Your Ref: OWPC15467
Our Ref: R/184/17/PD 08-08-2017
Please ask for:
Mrs A Gardner

Notification for prior approval under class C for a change of use from a shop (Class A1)
to a restaurant/cafe (Class A3)
51 Sea Lane Rustington

**APPENDIX ONE:
DRAWING SHOWING EXTERNAL EXTRACT AND VENTILATION EQUIPMENT PROPOSED**

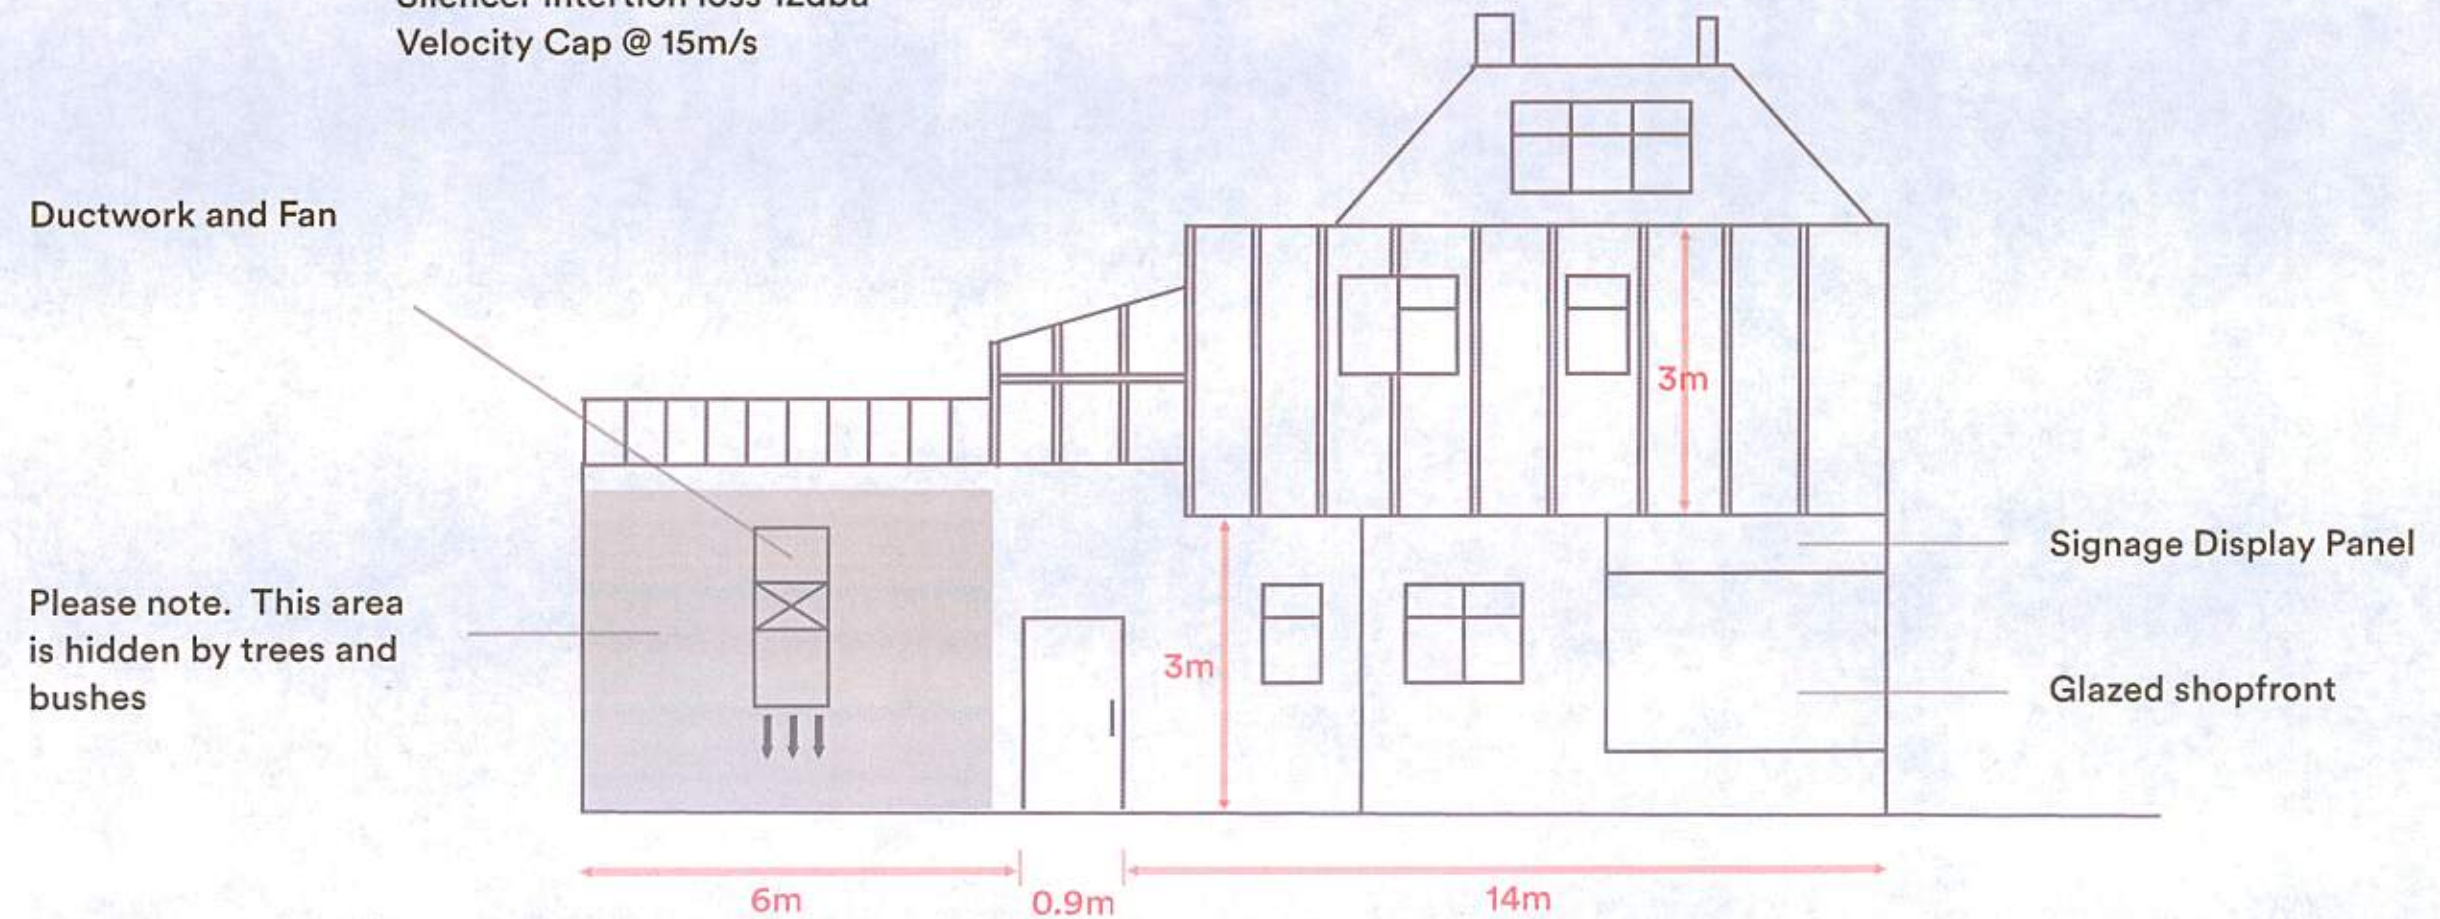
Noise and smells from the extractor fan onto neighbouring residential properties.
